Appeal Decision

Appeal Ref: APP/T2350/W/23/3325434

Land adjacent to Miles Hill, Moor Lane, Billington BB7 9JH

- The appeal is made under section 78 of the Town and Country Planning Act 1990 against a refusal to grant approval required under Schedule 2, Part 3, Class Q of the Town and Country Planning (General Permitted Development) (England) Order 2015 (as amended) (the GPDO).
- The appeal is made by Mr Tom Procter against the decision of Ribble Valley Borough Council.
- The application Ref 3/2023/0226, dated 15 March 2023, was refused by notice dated 5 May 2023.
- The development proposed is conversion/redevelopment of two agricultural buildings into 2 dwellings.

SHEET: BARN 1 EXISTING AND
PROPOSED PLANS AND
ELEVATIONS

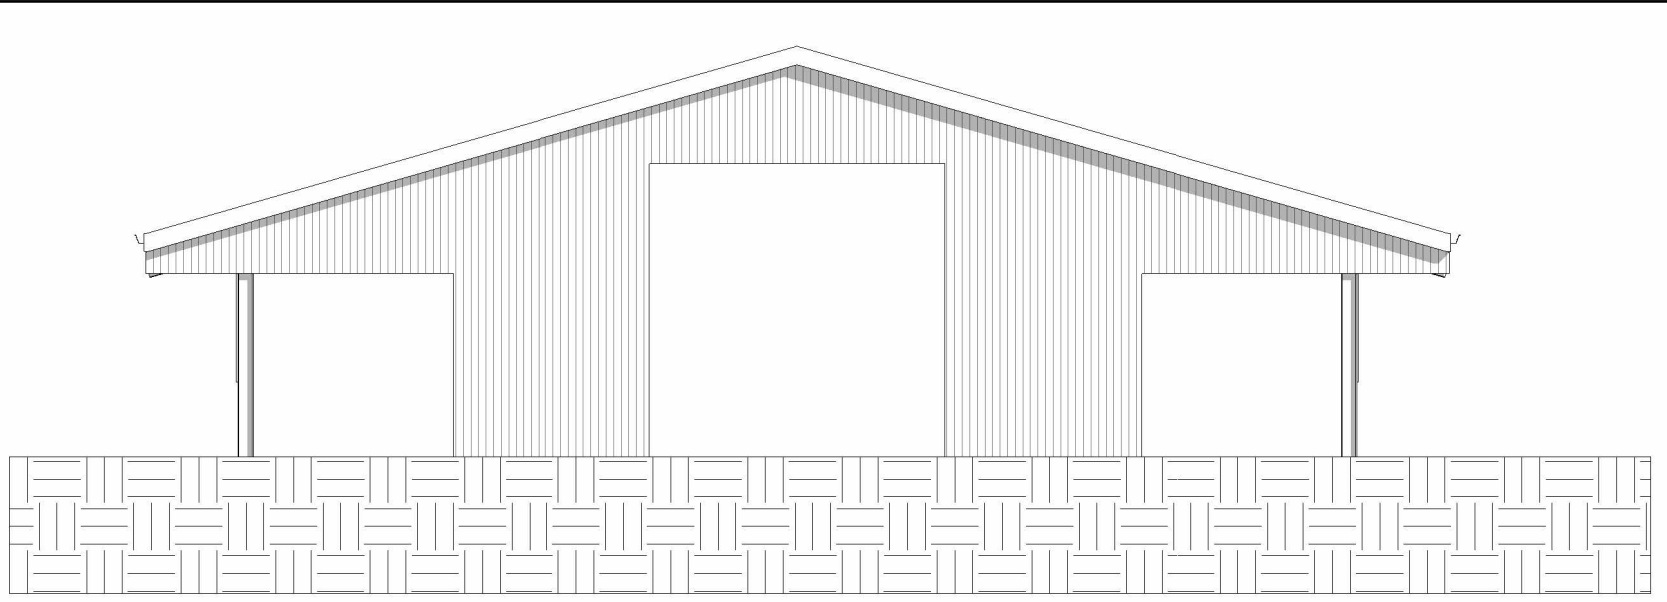
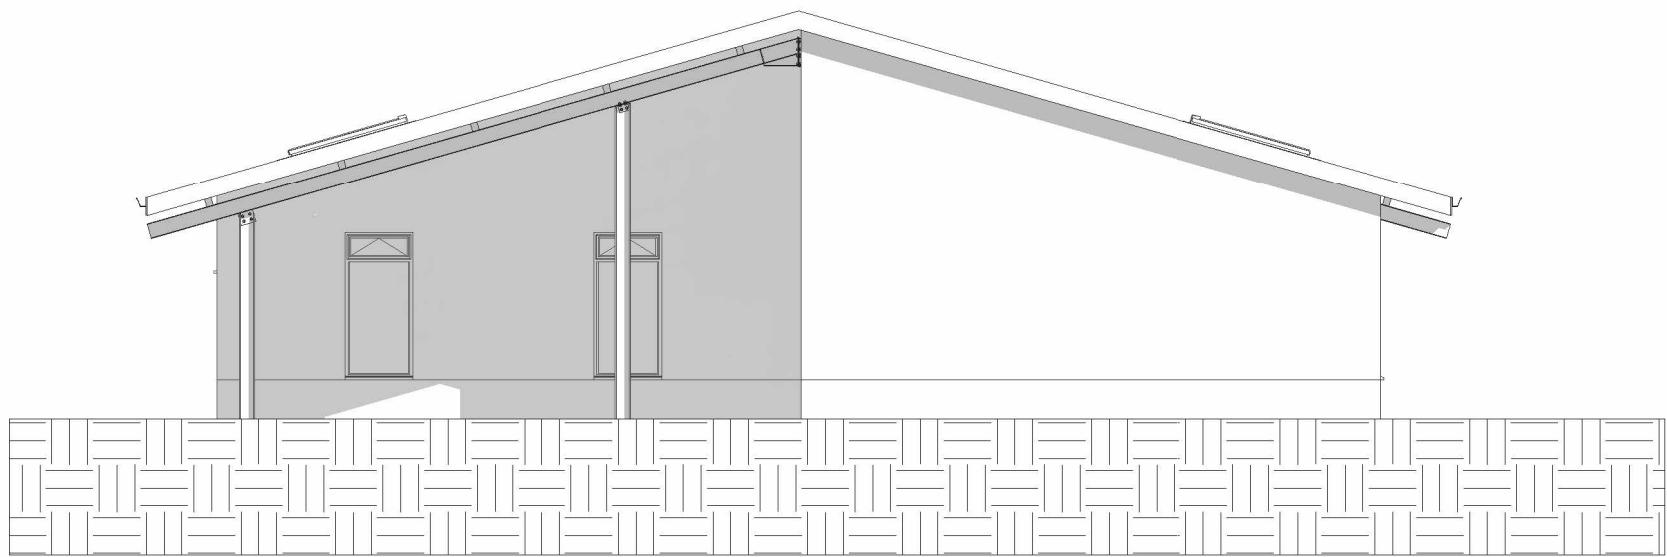
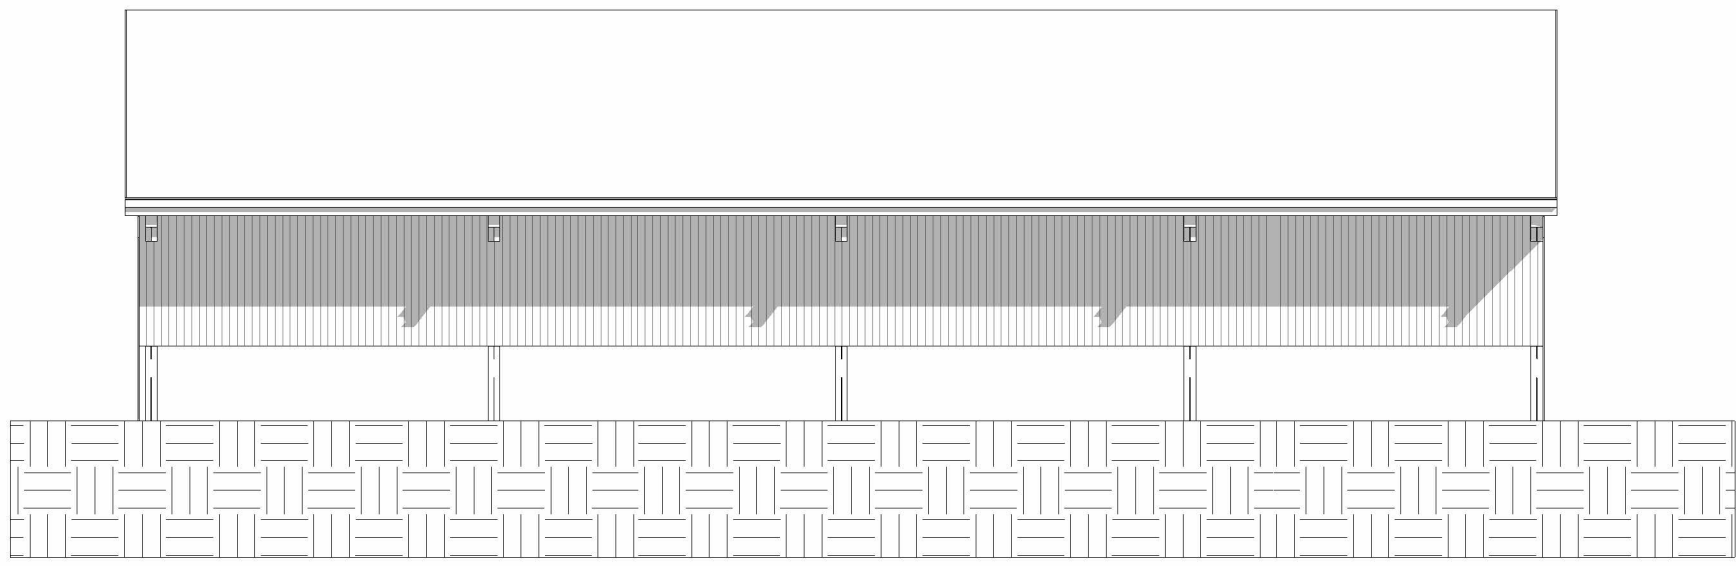
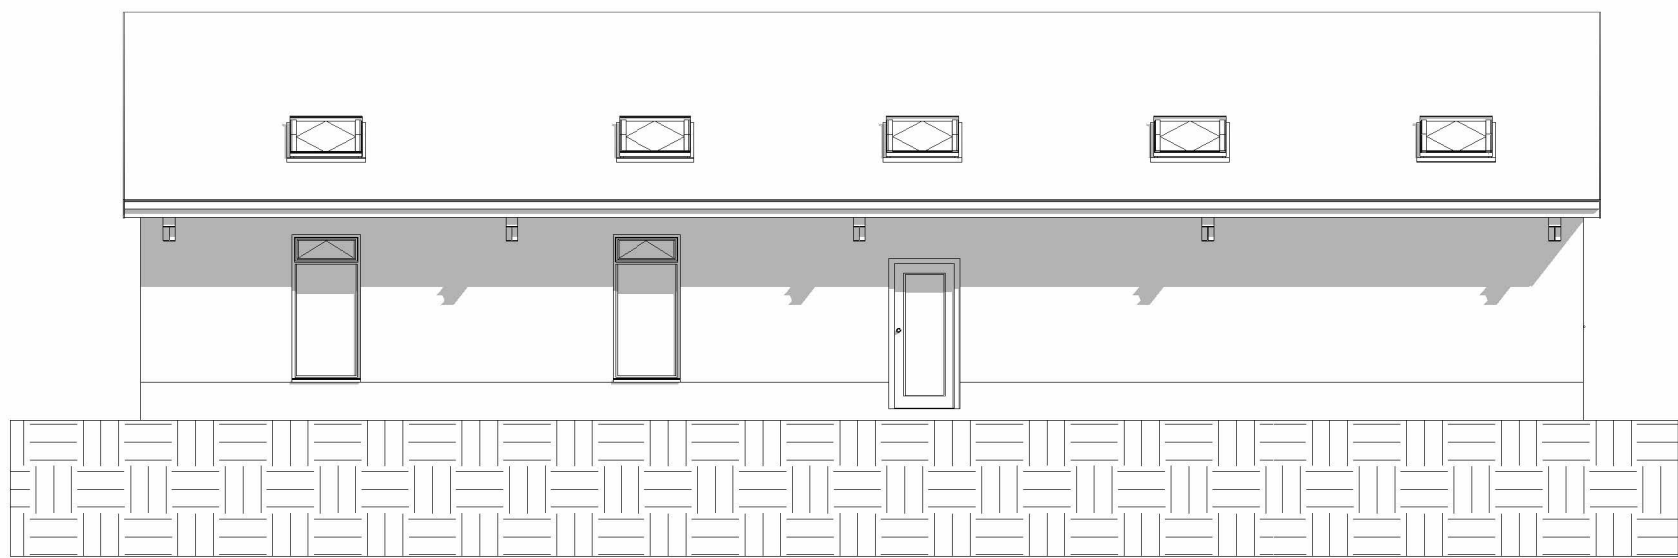
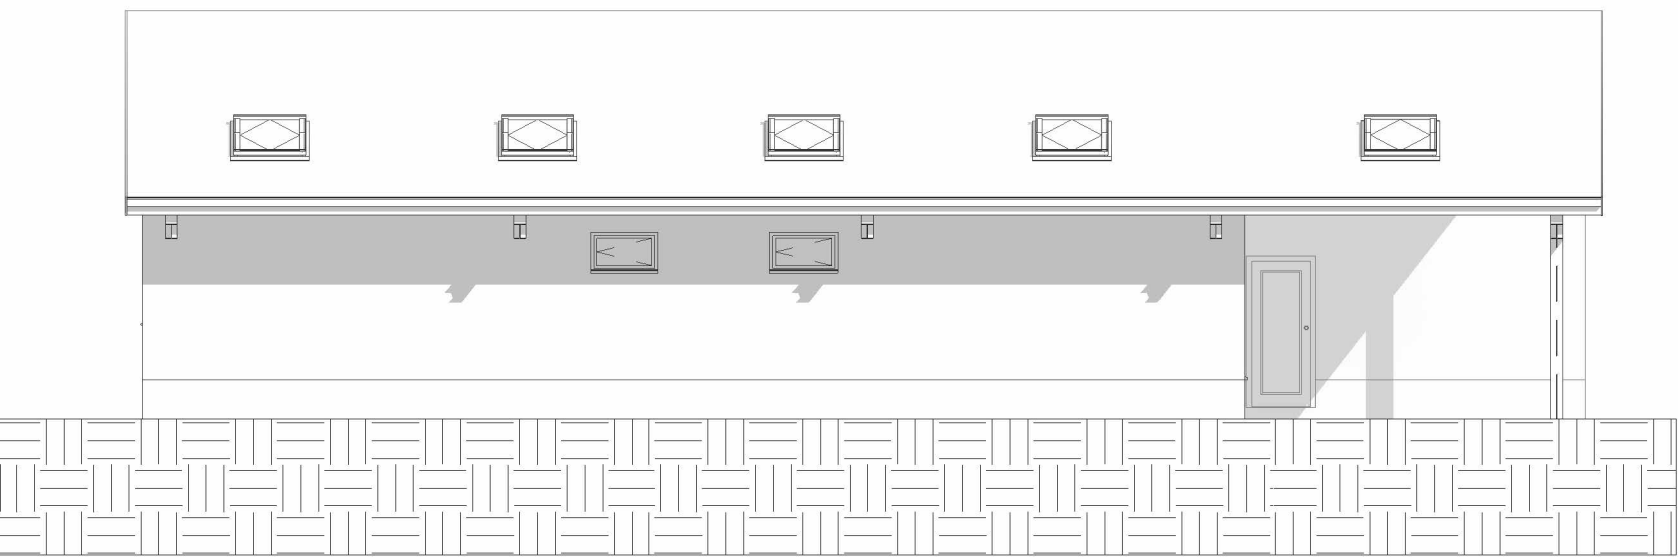
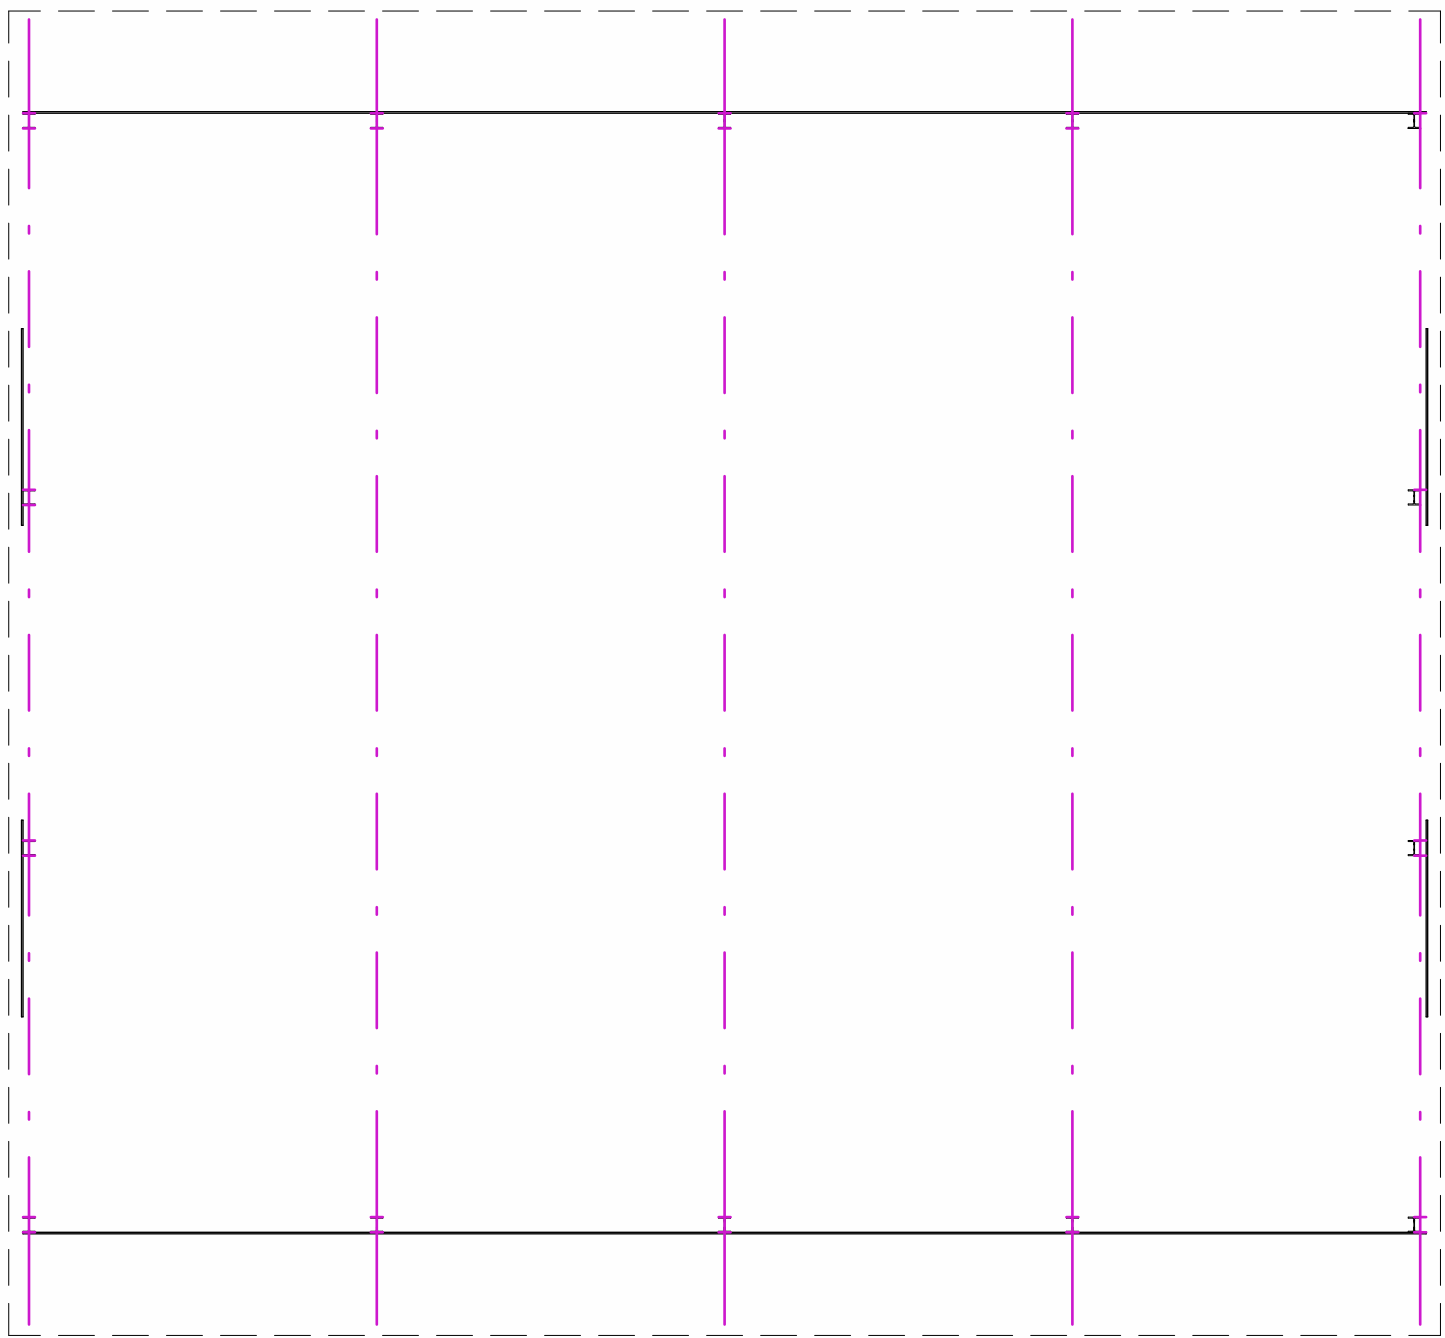
13. The main access into the easternmost barn, Barn 1, would be via a door into a hall part way along its north east side elevation and beyond the end of the retaining wall. As such, the external ground works are not necessary to provide access into Barn 1. There would be a further door serving a utility room in the recessed part of Barn 1 beneath the south east gable end canopy. In the absence of the external ground works, this door would not be easily accessible from the south east due to the abrupt change in ground levels at the edge of the existing building envelope. However, it would not be the main or visitor entrance from the parking area and it would be accessible from the already lower lying land to the south west of the building.

21. Compared to the earlier scheme, the size of some of the elevation openings has been reduced. However, irrespective that the rooflights and openings may reflect the proposed internal layout, there would still be a large number of new domestic openings and extensive repositioning of openings. While the existing large gable end openings may not be historic or traditional cart door openings, they do contribute to the agricultural character and the interpretation of the buildings. In contrast, the proposed domestic openings in the gable end elevations would not reflect or respect the scale, number or position of the existing relatively simple agricultural openings. I note the appellant's concerns in relation to the potentially greater adverse visual impact if large openings were to be retained. Irrespective, the large number of domestic openings, and that are poorly-related to the existing arrangement, would contribute to the erosion of the functional appearance of the buildings.

22. The proposed rooflights would be more regularly arranged, but they would be increased in number. While there are a large number of existing rooflights, these appear to be corrugated plastic flush with the corrugated roof of the agricultural buildings. In contrast to these existing relatively unobtrusive rooflights, and by virtue of their number, domestic proportions and style, the proposed rooflights would be conspicuous to the detriment of the utilitarian appearance of the buildings. The appellant would be amenable to the imposition of a planning condition to control the design and appearance of the rooflights. However, I am not satisfied that this would be sufficient to mitigate the visual harm arising from the totality of the proposal.

24. The agricultural buildings are visible from around the highway access and from locations along the road. The nearby public right of way (the FP) affords clear views of the north east side elevation of Barn 1. Barn 2 is partly screened from the FP by Barn 1, but it is also partly visible and there are views of the north west gable ends of both barns from the FP. Therefore, notwithstanding local topographical variation and the distance to settlements, the proposal would be visible from locations in the surrounding area. The buildings would also be conspicuous overnight due to light spill from the numerous glazed openings including rooflights and at times of year when trees and hedges are not in leaf.
